El Paso County, Colorado
Project: T-Mobile Equipment Upgrade
Sunview RV Park, 10410 State Highway 115, Ivywild, CO

SUBJECT: PLAN REVIEW RESPONSE COMMENTS (Crown BUN: 855798, App: 597407)

Per Rev 2 FCDs issued 8/03/2022, the subject drawings have been modified as follows:

C-1.1

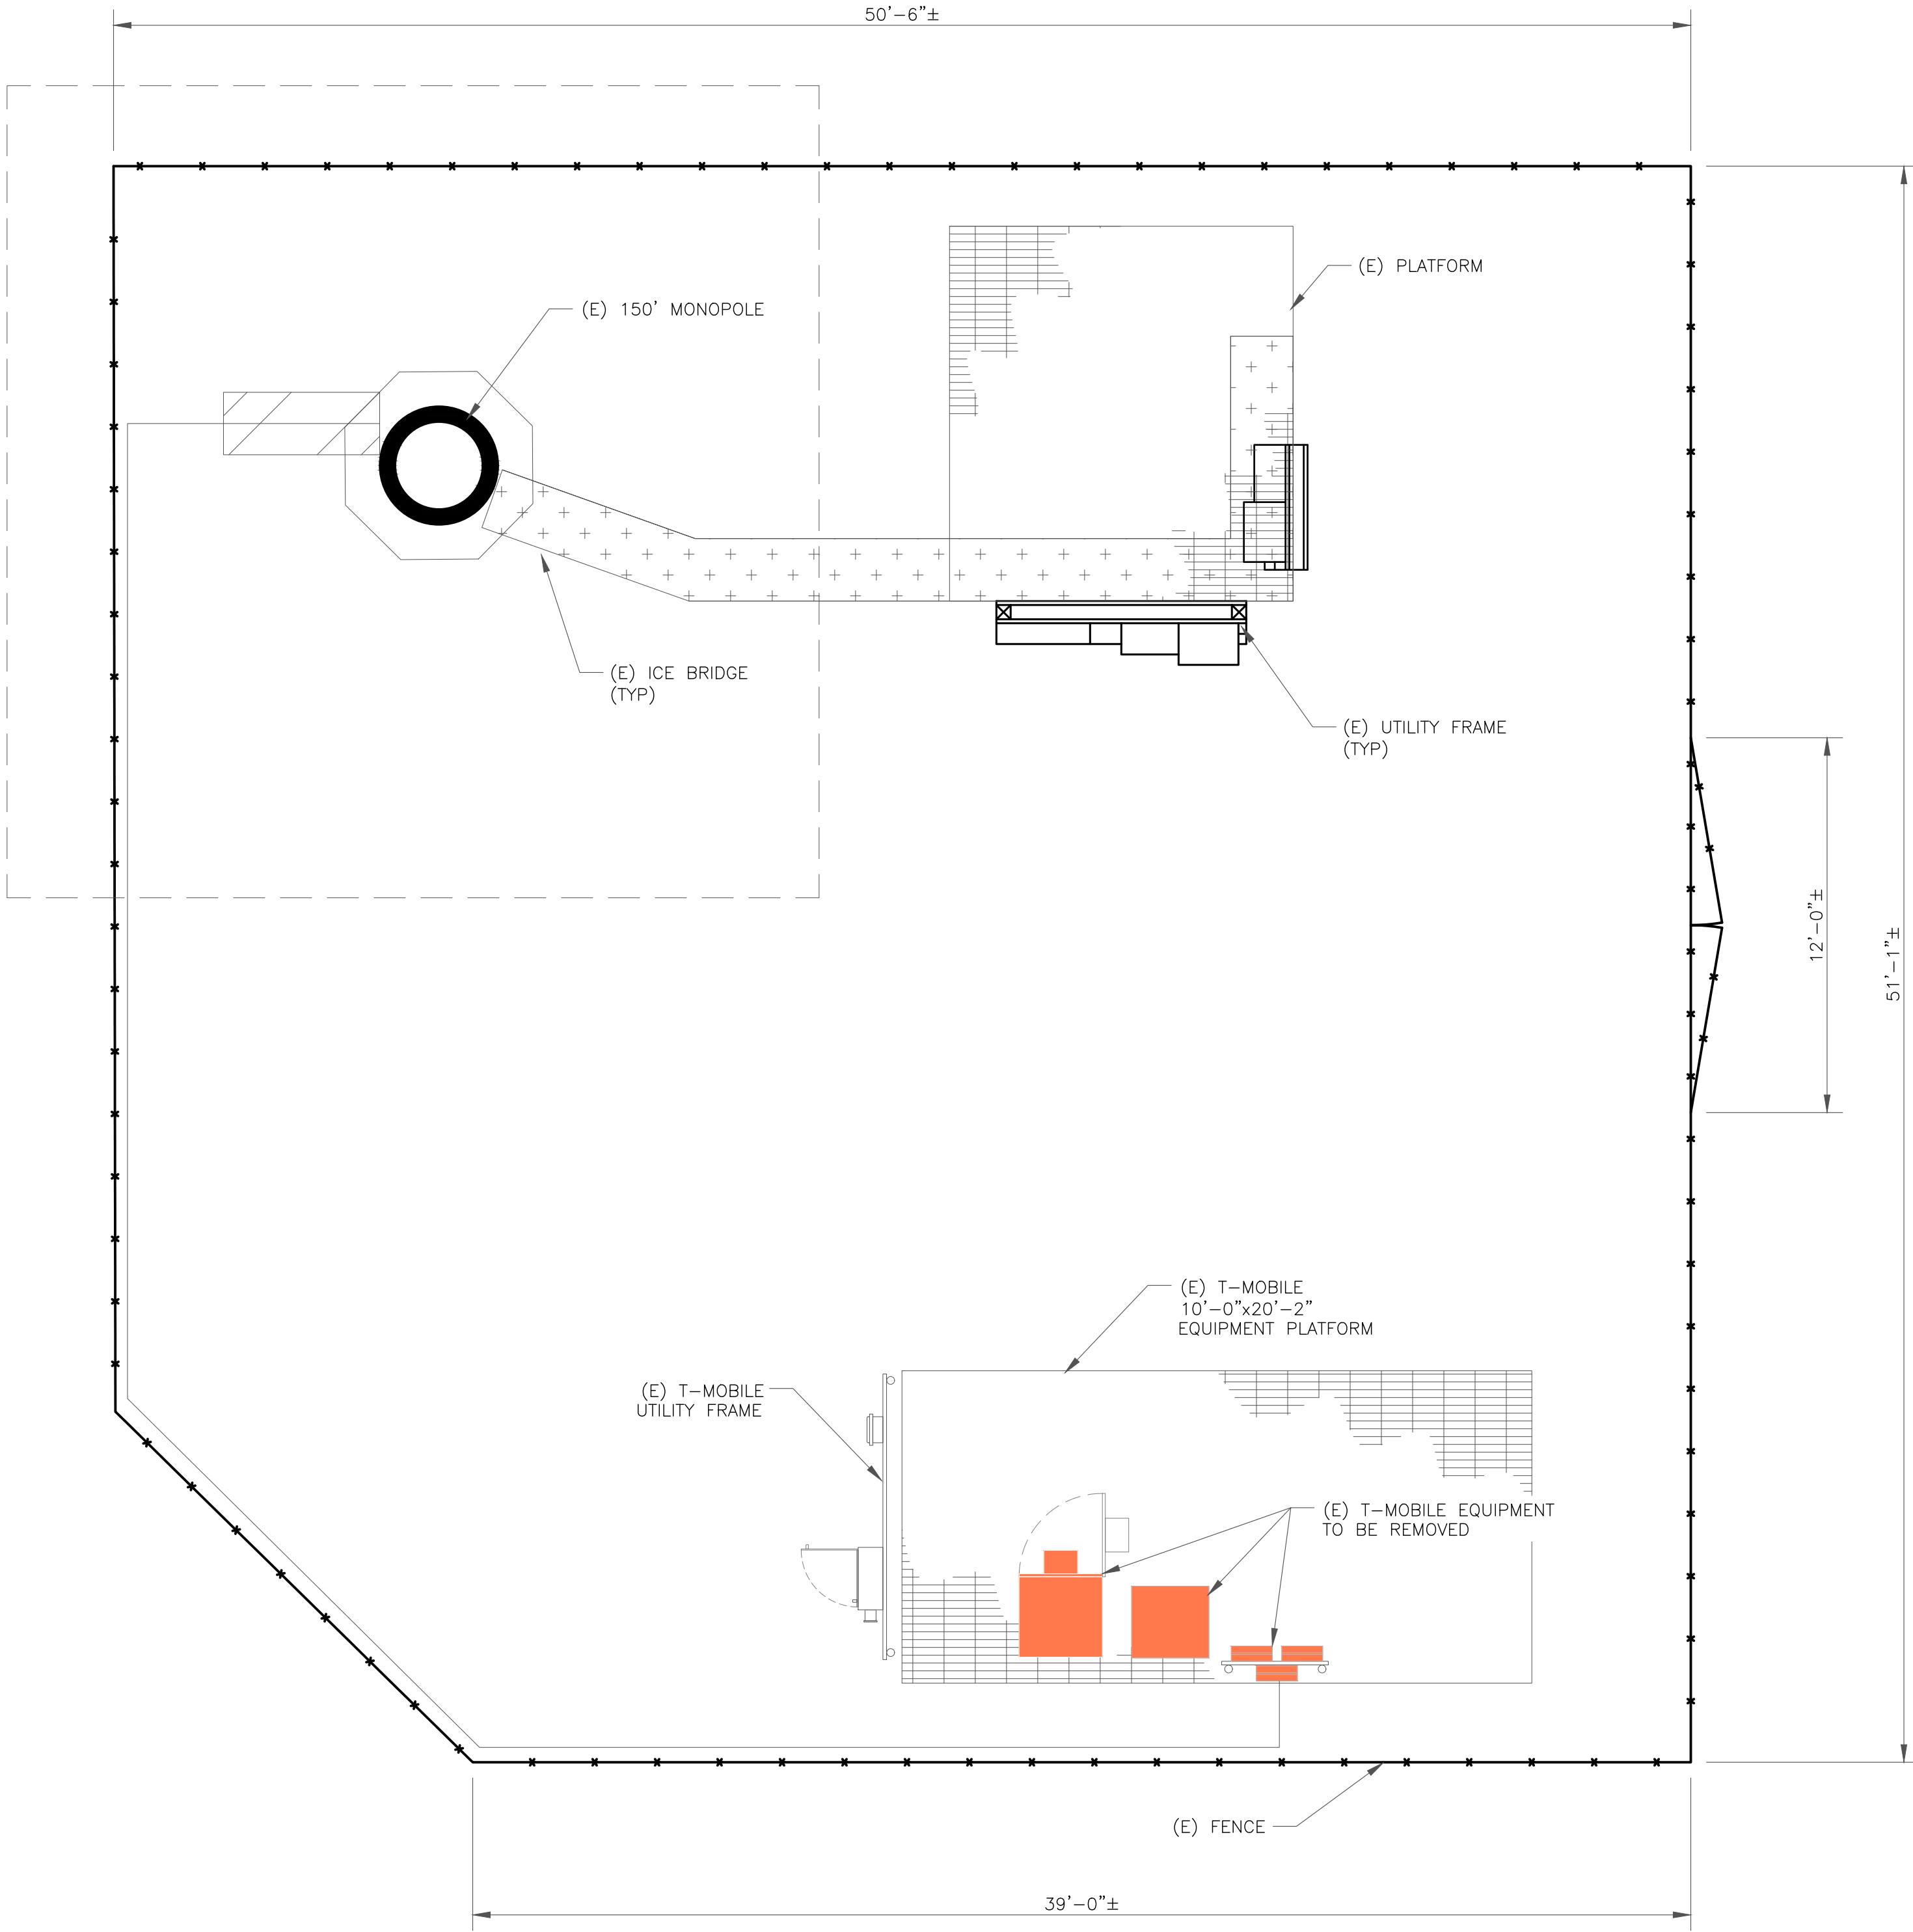
1. Please add a site plan showing the tower in relation to all property boundary lines as well as any easements on the property...
 - Overall Site Plan page (provided by Crown and completed by Fullerton Engineering Design, latest rev dated 04.10.15) reflecting this info has been inserted as new sheet C-1.1.
